NK Comment/Request	Response	File/Drawing Ref
Seeks written confirmation that there will be some buff colour in concrete for skatepark area.	This can be confirmed yes, please see attached referred to drawing which confirms 'a mixture of natural concrete, charcoal dye & terra cotta dye'.	See Bendcrete drawing: BARNESLEY SKATEPARK FEATURES rev B
Seeks written confirmation that the metal piping work in parkour area will be yellow-orange colour. Preference for RAL 1003 Signal Yellow.	Yes it can be confirmed that this equipment in the parkour area will be RAL 1003 Signal Yellow.	-
Seeks written confirmation of colour of metalwork in skatepark area.	This metalwork is left 'natural' without any paint/colour because this otherwise is scratched and chipped off by the skating activities.	-
Seeks clarity as to whether additional planters could be incorporated into certain areas of hardstanding.	Unfortunately this is not possible. This is in part owing to budget and also in part owing to the operational challenges of incorporating these, as they would require separate specialist vehicle/equipment to move them whenever necessary for utility access through the site. If wheeled planters were selec

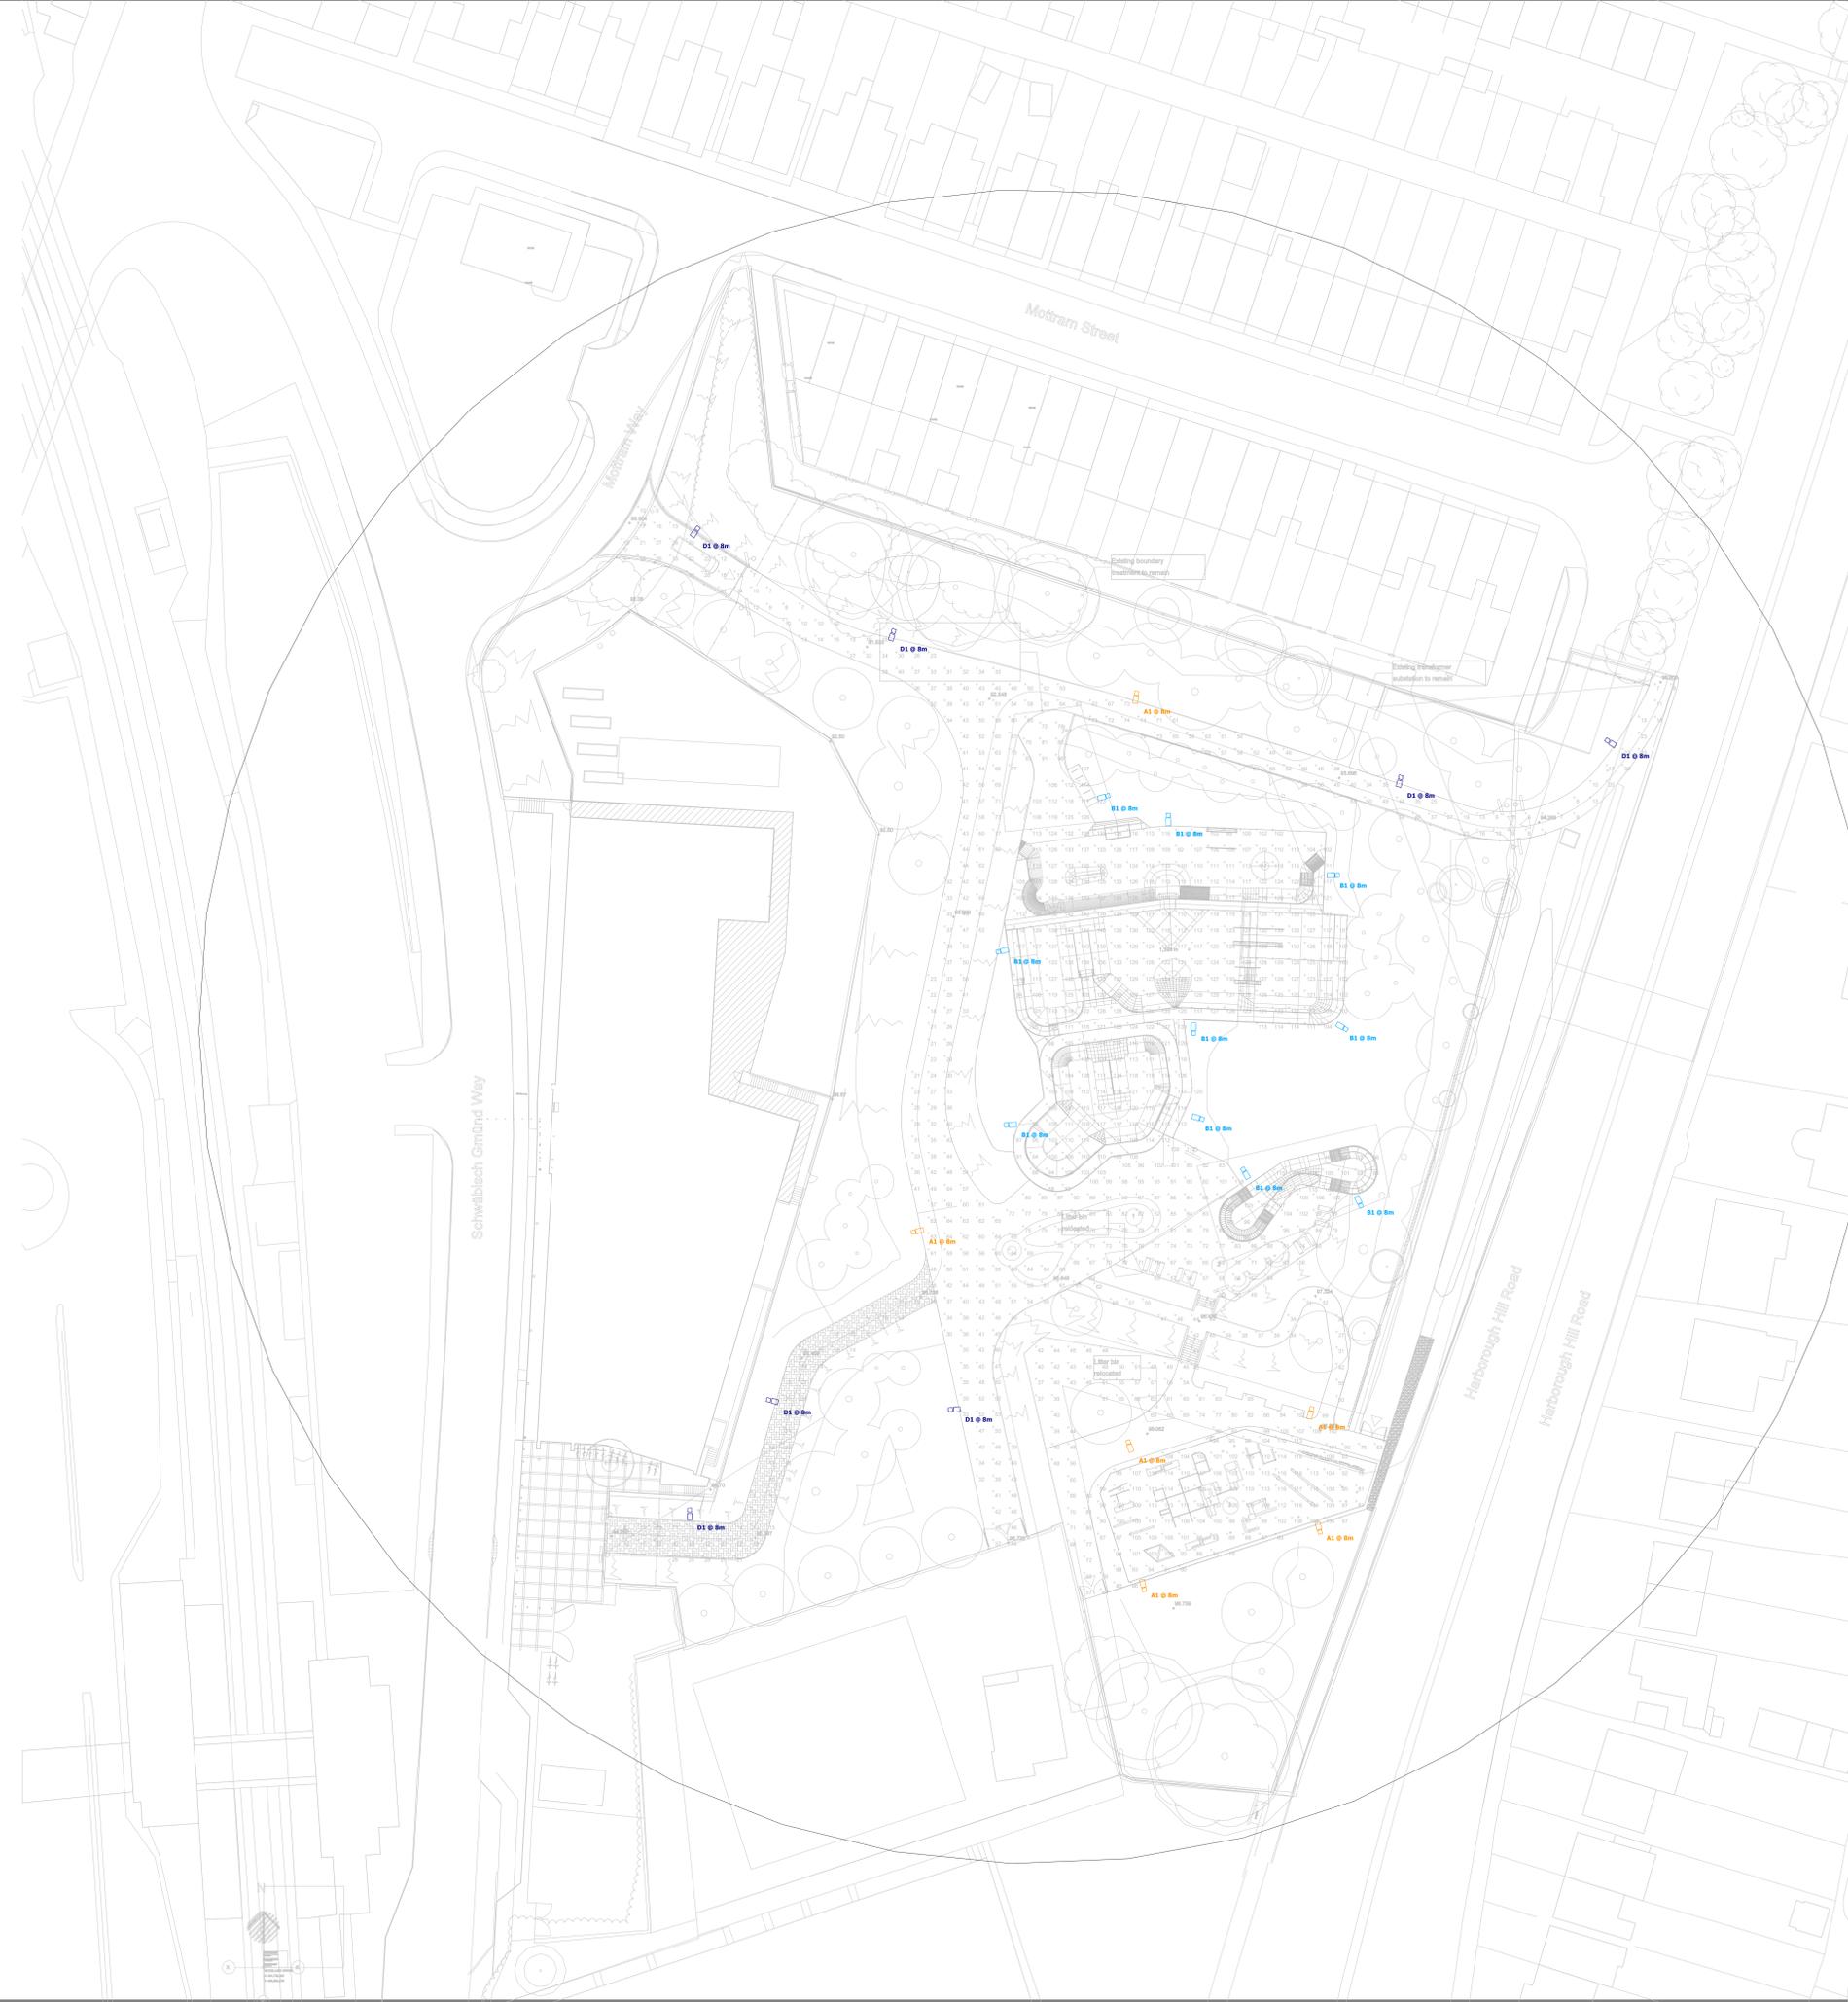
NK confirms satisfactory outcome of discussion on lighting columns and impact attenuation surfacing.	n/a	-
--	-----	---
